Development Management
Lincolnshire County Council
County Offices
Newland
Lincoln LN1 1YL
Tel: 01522 782070
developmentmanagement@lincolnshire.gov.uk

Application Ref: H16-0278-26

Proposal: **Demolish existing factory/warehouse to facilitate proposed residential development consisting of 230 dwellings including associated infrastructure and public open spaces**

Location: **Land off Meadow Way, Spalding**

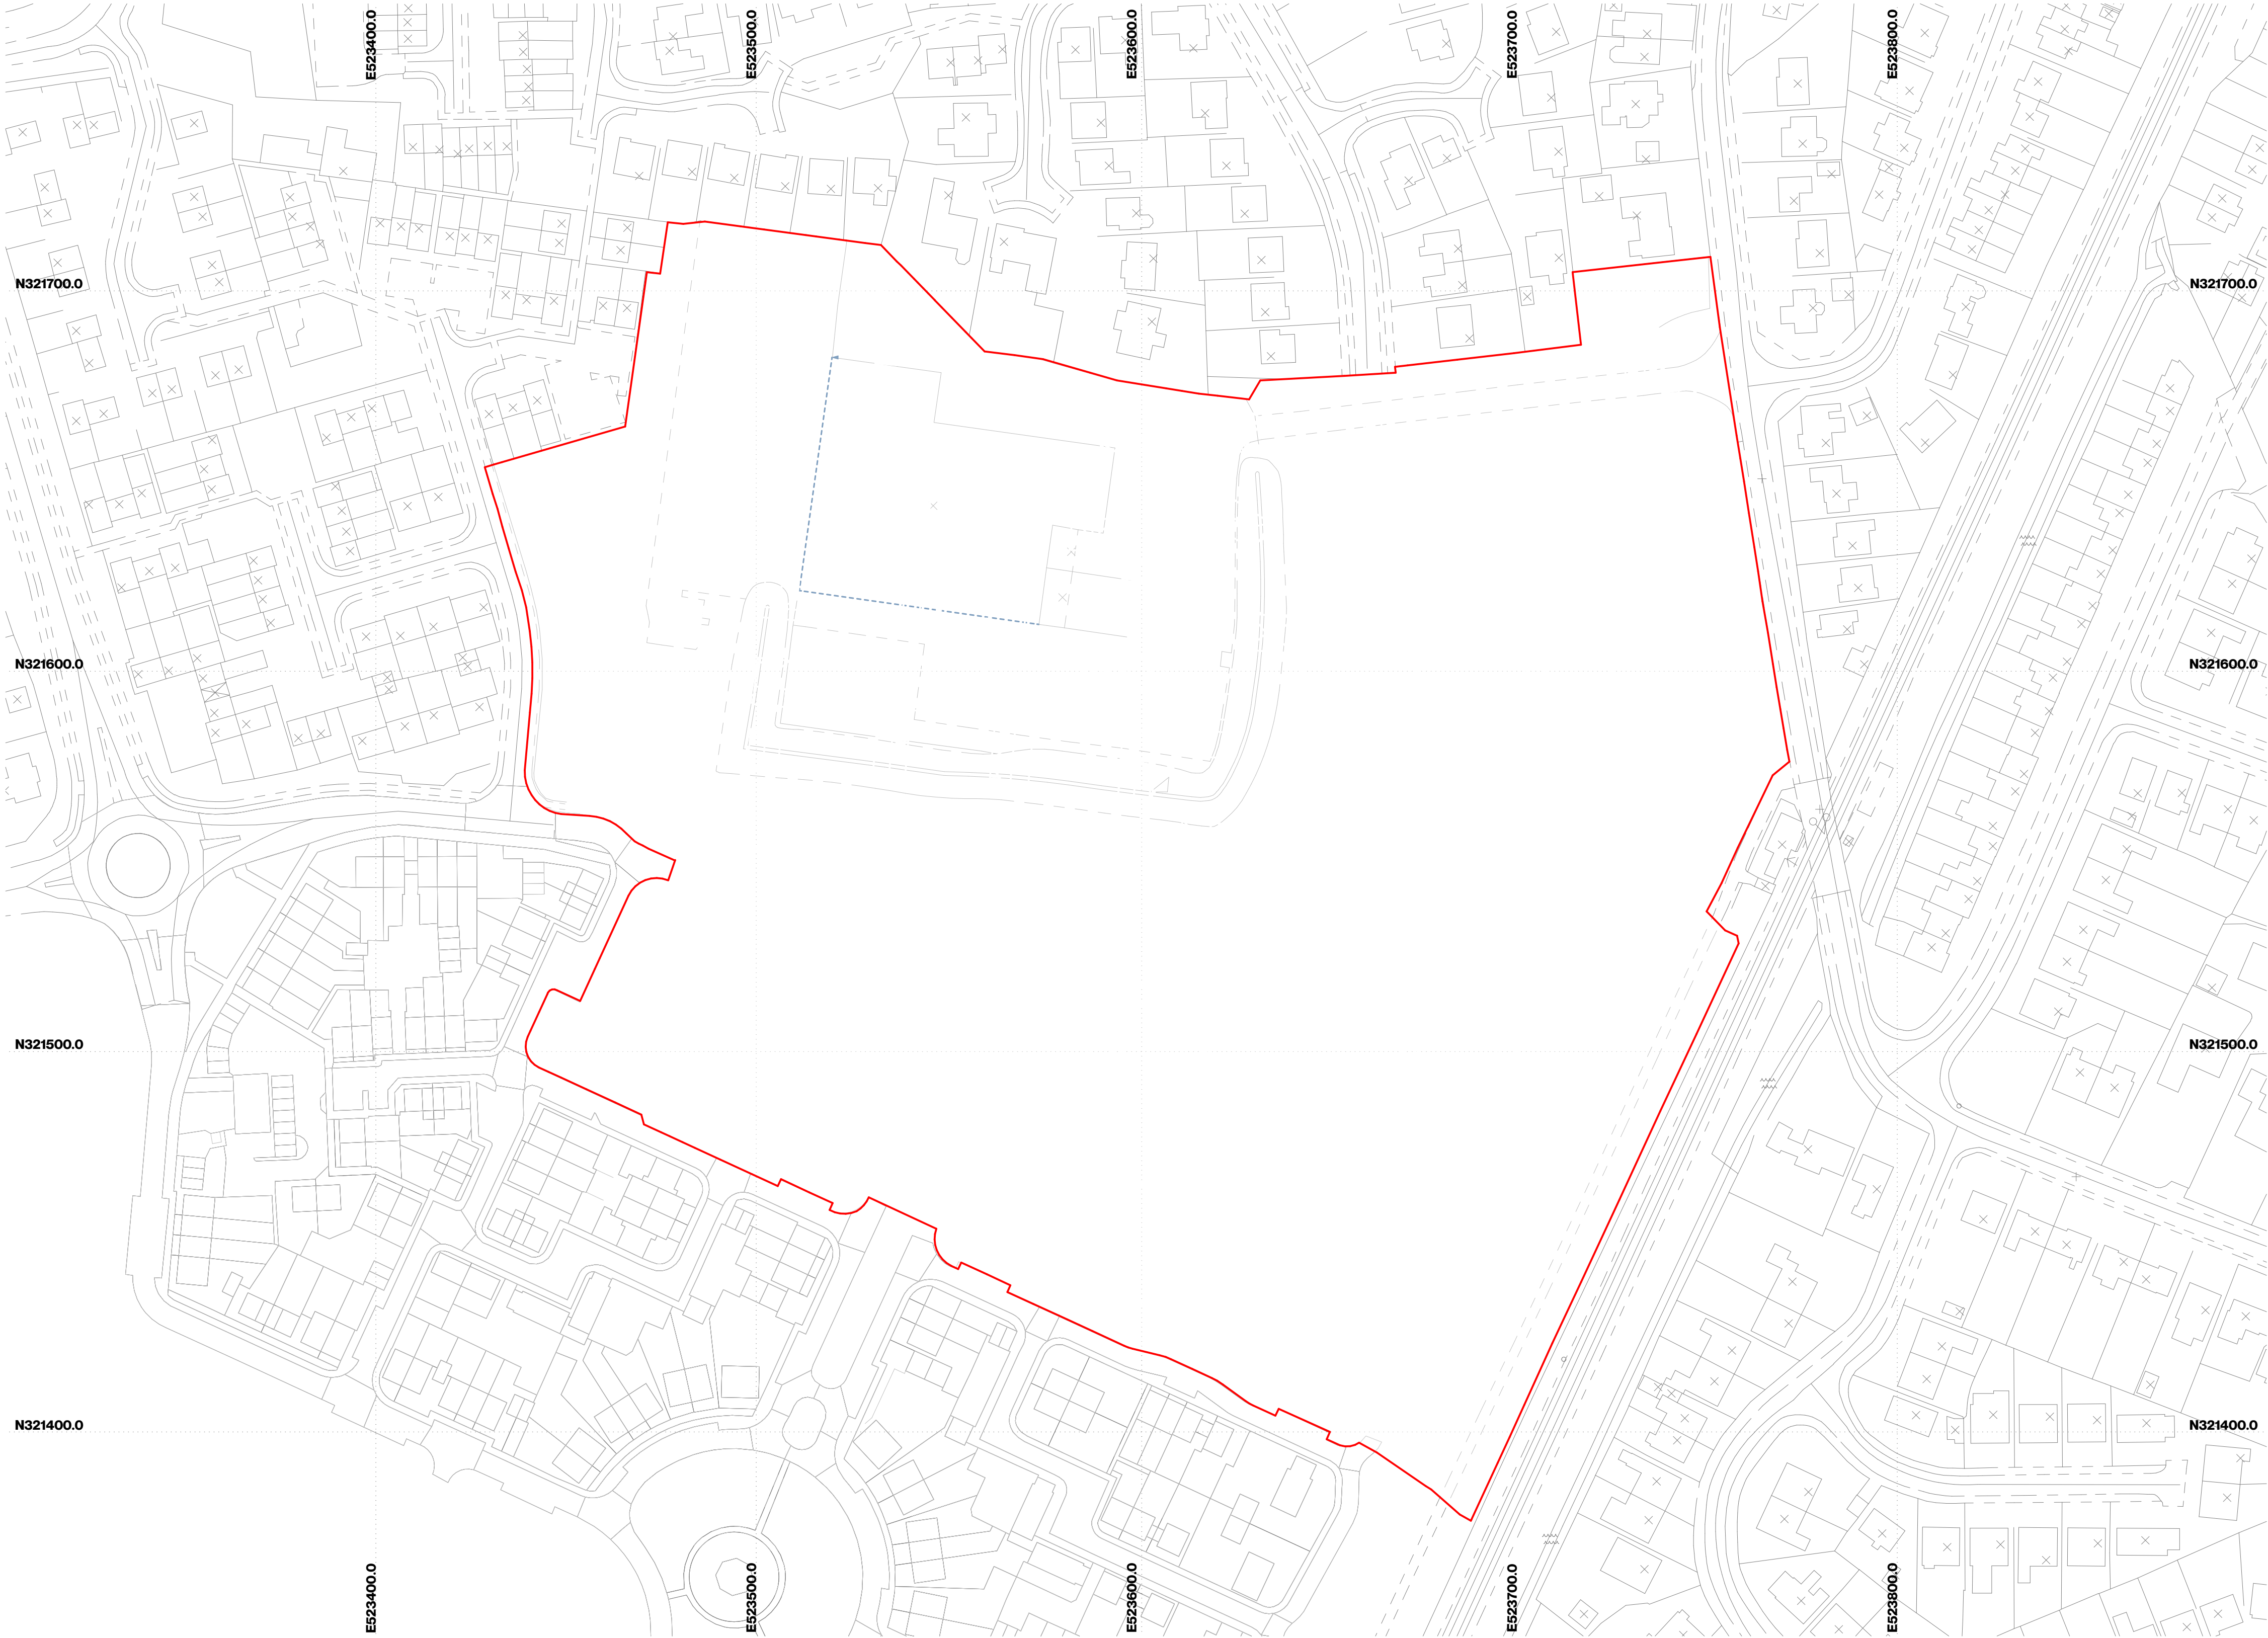
- The proposed cycle/pedestrian route falls short of the existing route and connectivity cannot be made. The existing route on the southern side of Meadow Way ends at the junction of the estate road and the proposed route commences on the northern side some distance short on connection. We suggest that the new route either commences further back in front of plot 218, if this is a suitable and safe crossing point or, extends on the southern side in front of the attenuation basin up to the link footpath and then crosses the carriageway making connection in front of plot 204, again if this is a safe and suitable crossing point.

- The proposed pedestrian link from the northern side of the development between plots 118/119 and 123-128 connecting on to Hoekman Way needs to be a pedestrian/cycle route of 3.0 metres wide.

- There needs to be an adopted pedestrian link from the end of the turning head near plot 189 making connection with the shared surface road. Additionally, please provide details of

how vehicular access will be restricted to ensure there is no vehicular connection, as this would change the trip generation from Hawthorn Bank.

In addition to the above, we ask the applicant to provide a parking justification for plots 223-230 as the proposed number of parking spaces seems short of what is required within the Local Plan. We also ask if there is a requirement to provide a break in the carriageway between plots 002/003, this being a proposed private drive, where this could potentially become an edge lane/shared surface adopted road providing further connectivity. Further to previous phases on the eastern side of the development, there was a scheme providing footways with street lighting within the POS area. Can the applicant advise if this is still the case and will there be continuation through the POS for this proposed development.
